Appeal Decision

Appeal Ref: 6006532

34 Pepys Close, Ickenham UB10 8NY

DRG No. 2438.3 REV D

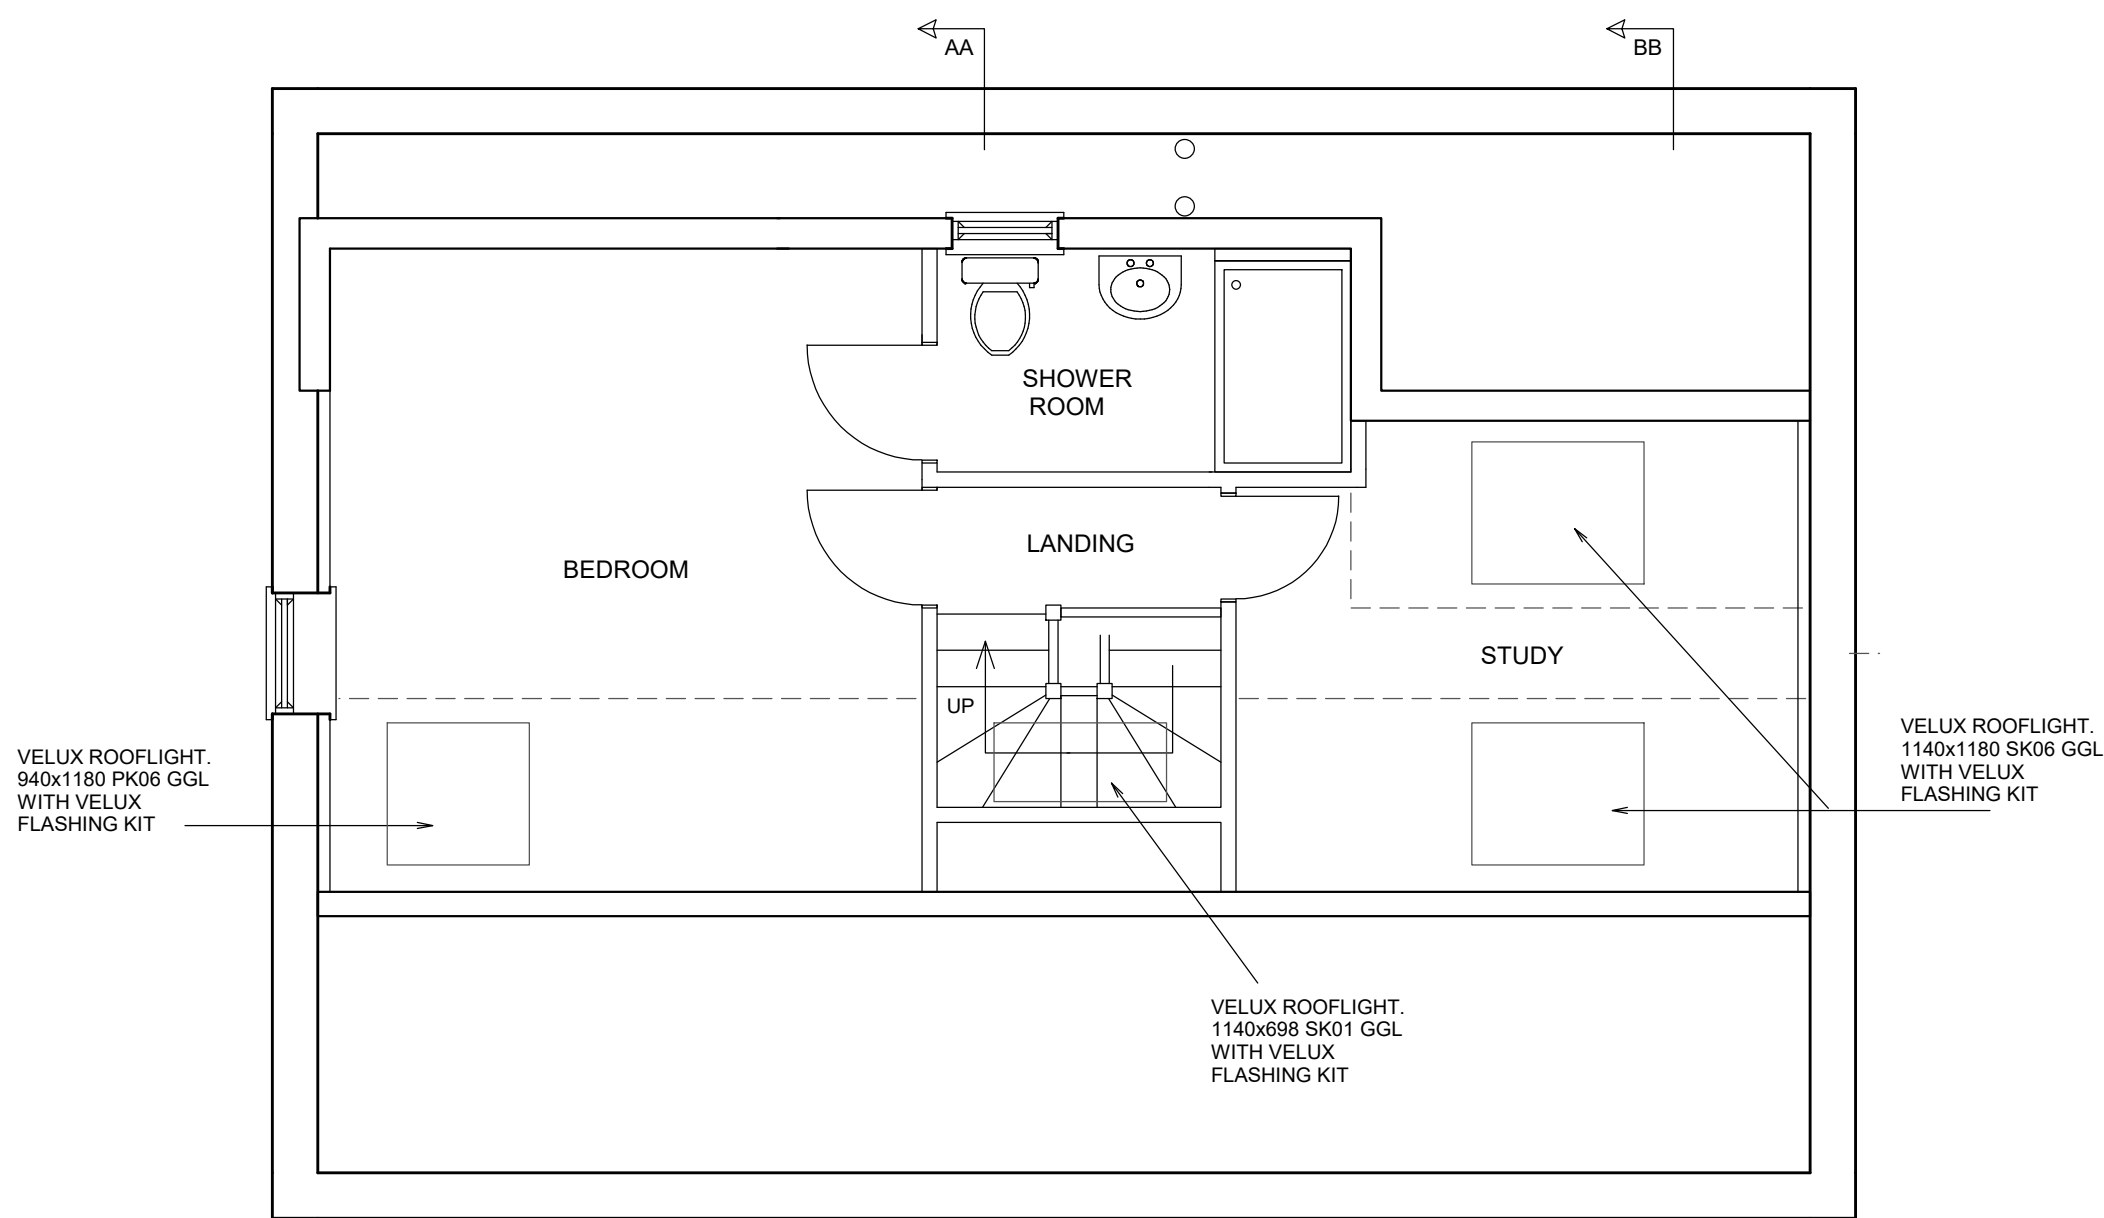
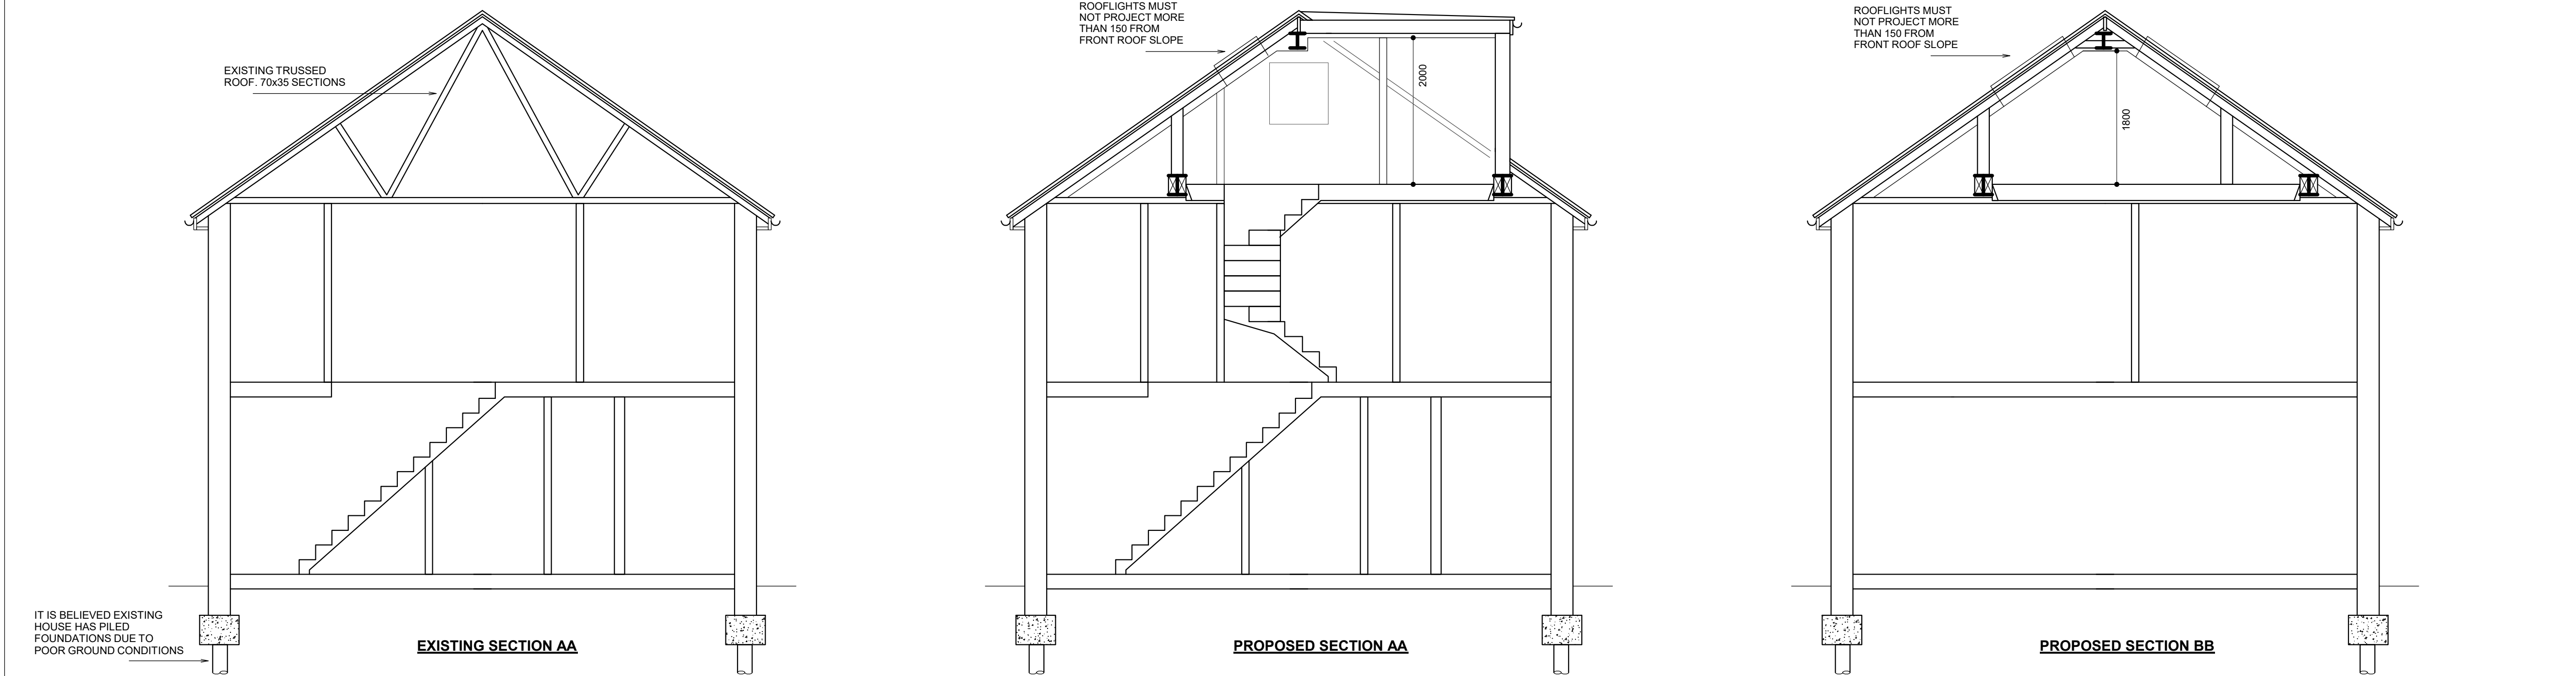
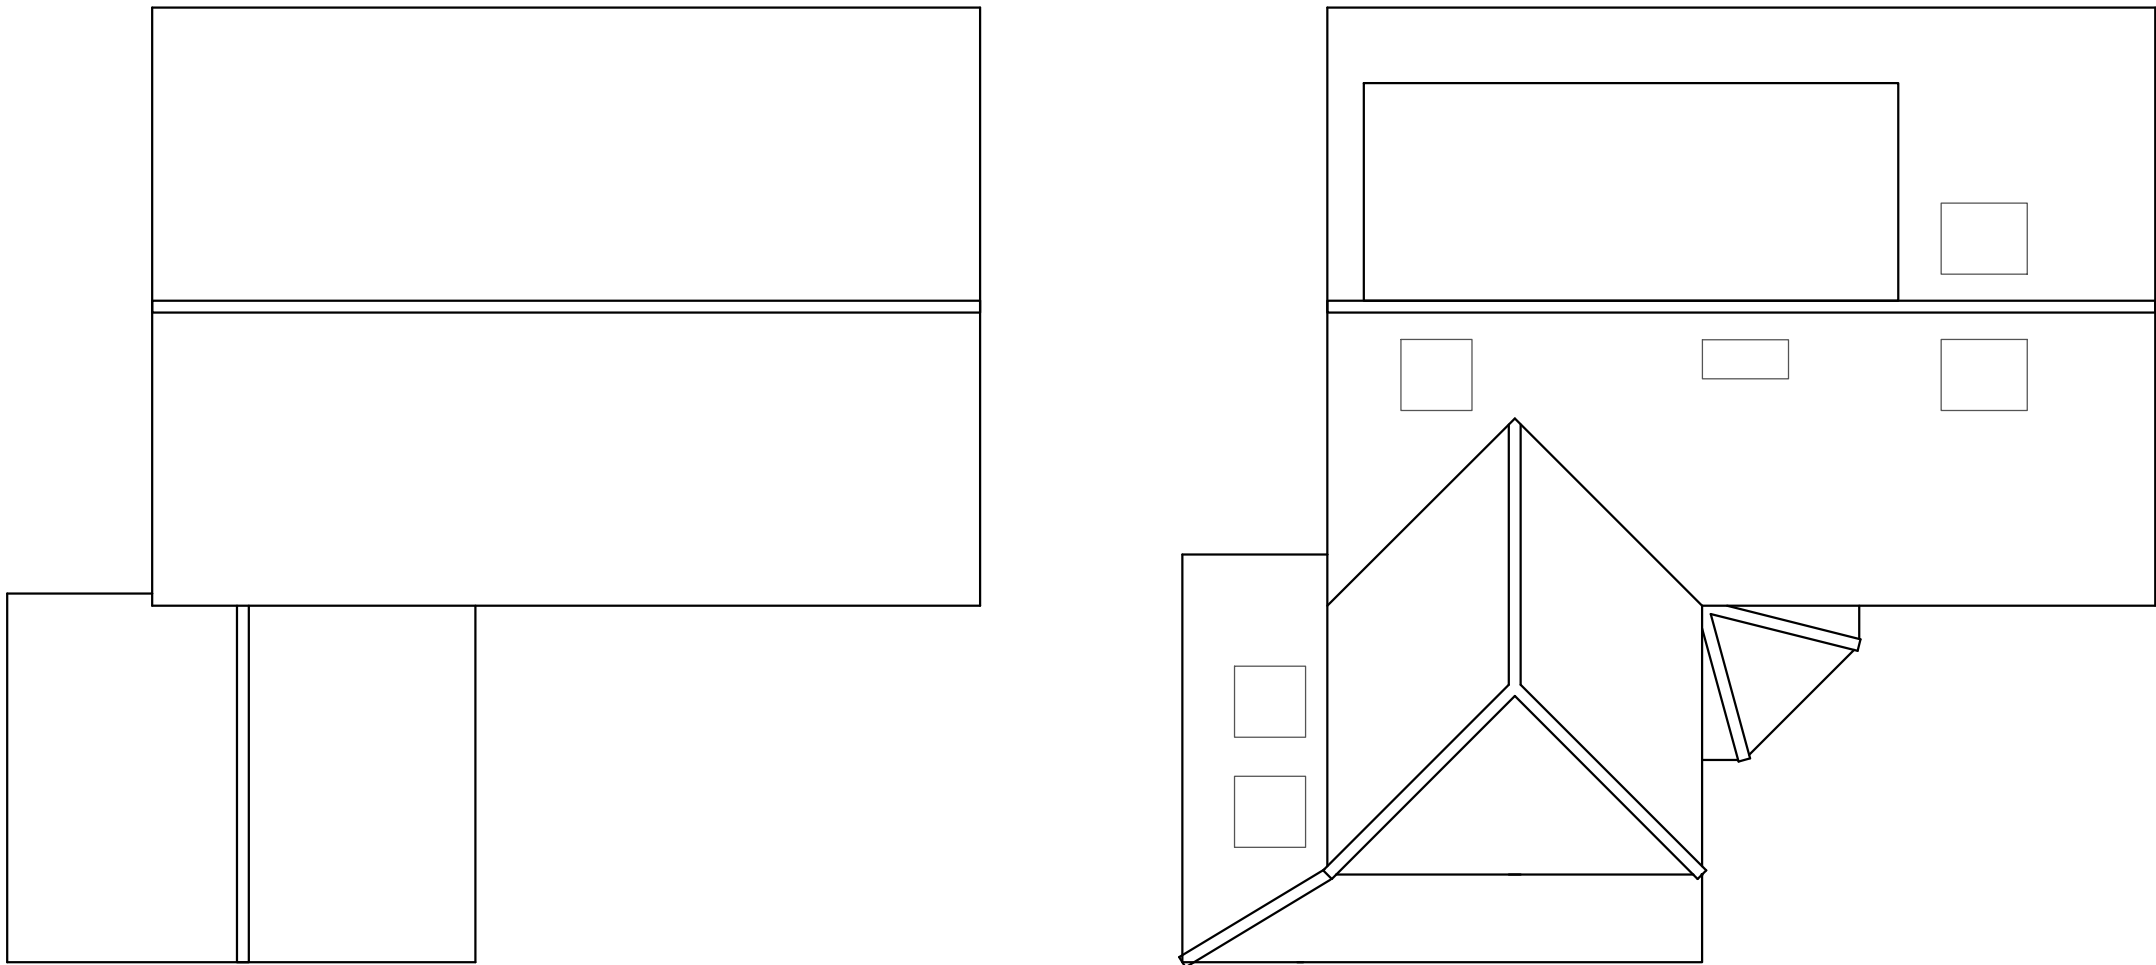
14. The Council does not object to the proposed dormer or other windows, and I have no reason to disagree. It would be positioned on the western elevation and, given its location, would not appear prominent within the wider street scene, being largely limited to views obtained directly in front of the property. It would be modestly sized in the context of the existing roof and through using a simple unfussy shape would reflect the modern feel of the host dwelling. The lack of harm in this respect would ensure that the character and appearance of the CA would be preserved.

16. I am satisfied that the proposed dormer overcomes the concerns regarding loss of privacy raised in appeal 3364612. It would contain only a single, small window, which would face directly onto a blank wall, with an additional window inserted into the southern elevation in order to provide natural light to the bedroom. Given their siting and orientation, neither window would result in unacceptable overlooking beyond that already experienced from existing south-facing first-floor windows.
17. The appeal process is not intended to serve as a means to evolve or revise a scheme. It must be determined based on the proposal submitted to the Council and made available for public consultation. Whilst the apparent lack of engagement

2. The appeal is allowed and planning permission is granted for the dormer window and rooflight on the western elevation, three rooflights on the eastern elevation and window in the second-storey southern elevation at 34 Pepys Close, Ickenham UB10 8NY in accordance with the terms of the application, Ref: 79176/APP/2025/2905, so far as relevant to that part of the development hereby permitted and subject to the following conditions:

- 1) The development hereby permitted shall begin not later than three years from the date of this decision.
 - 2) The development hereby permitted shall be carried out in accordance with approved plans DRG No. 2438.2 REV F and DRG No. 2438.3 REV D insofar as they relate to the dormer window and rooflight on the western elevation, the three rooflights on the eastern elevation and the window in the second storey southern elevation only.
